Department of Primary Industries

Boggabri Coal Project (PA 09_0182 Mod 5) Proposed Modification

Boggabri Coal Project (PA 09_0182 Mod 5) Proposed Modification Detailed Groundwater Comments on Boggabri Coal Mine Modification 5

Figure 3: Proposed Borehole Locations and Ancillary Infrastructure

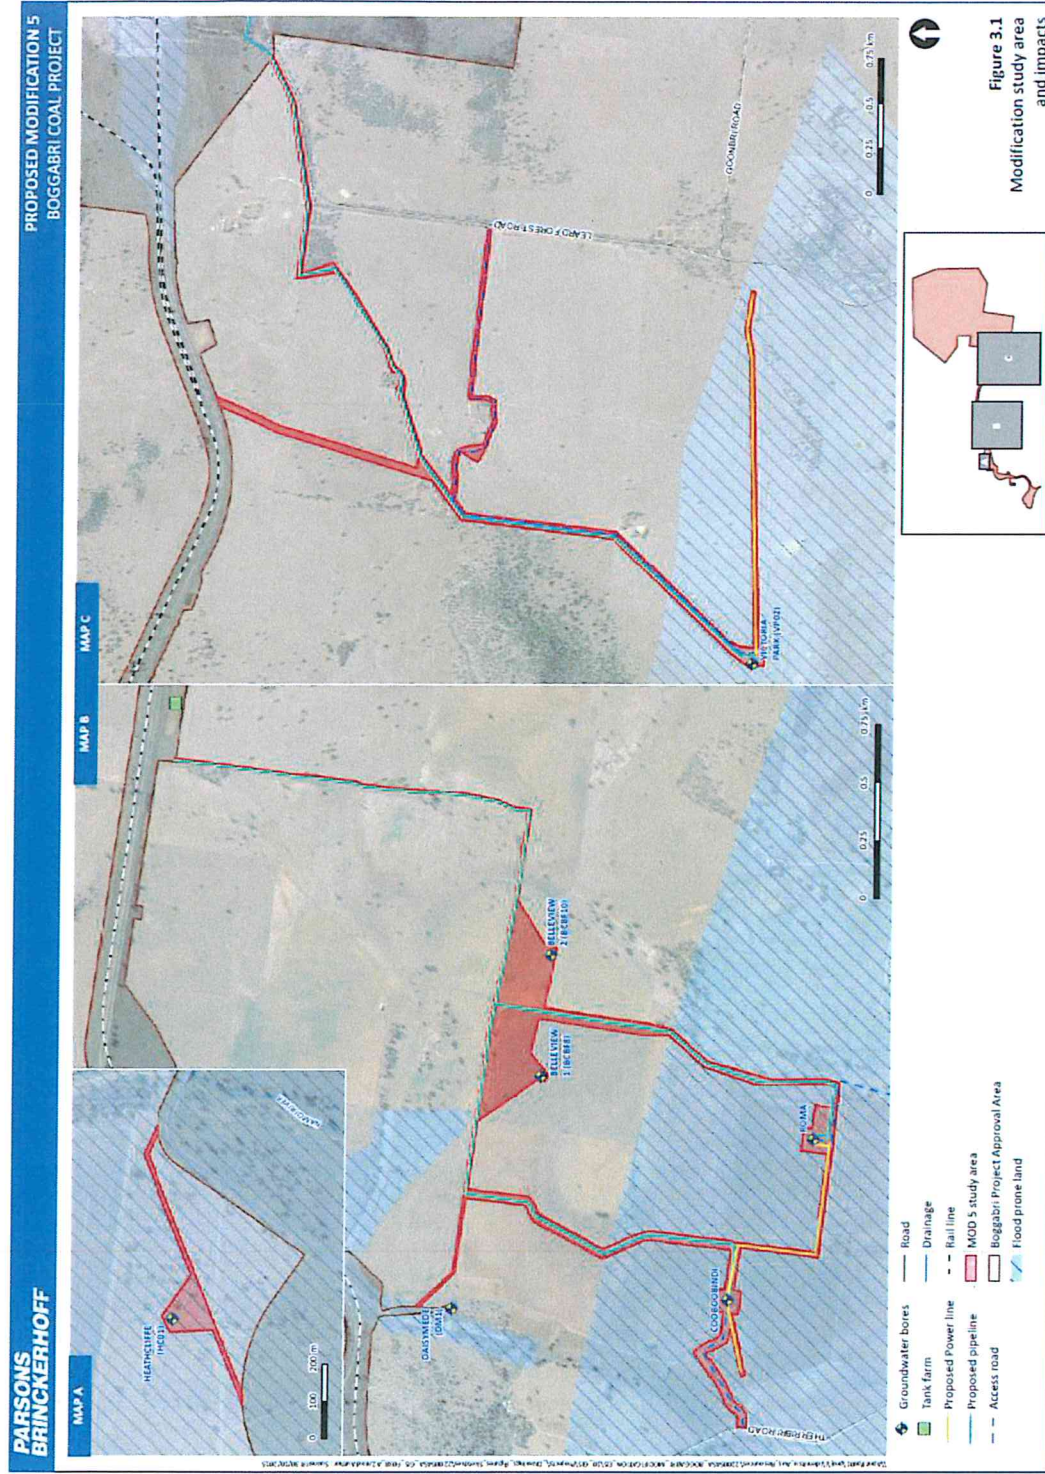
However, Figure 6.2 in the EA identifies the Heathcliffe bore is located in Zone 5, whilst all the other bores are in Zone 4. There is no record currently of Boggabri Coal holding a WAL in Zone 5, therefore they would be required to obtain the appropriate entitlement.

The volume of groundwater available to Boggabri Coal is incorrectly stated. There is no mention of Boggabri Coal being required to obtain access licences in Upper Namoi Zone 5 (Gin's Leap to Narrabri) Groundwater Source for the Heathcliffe bore.
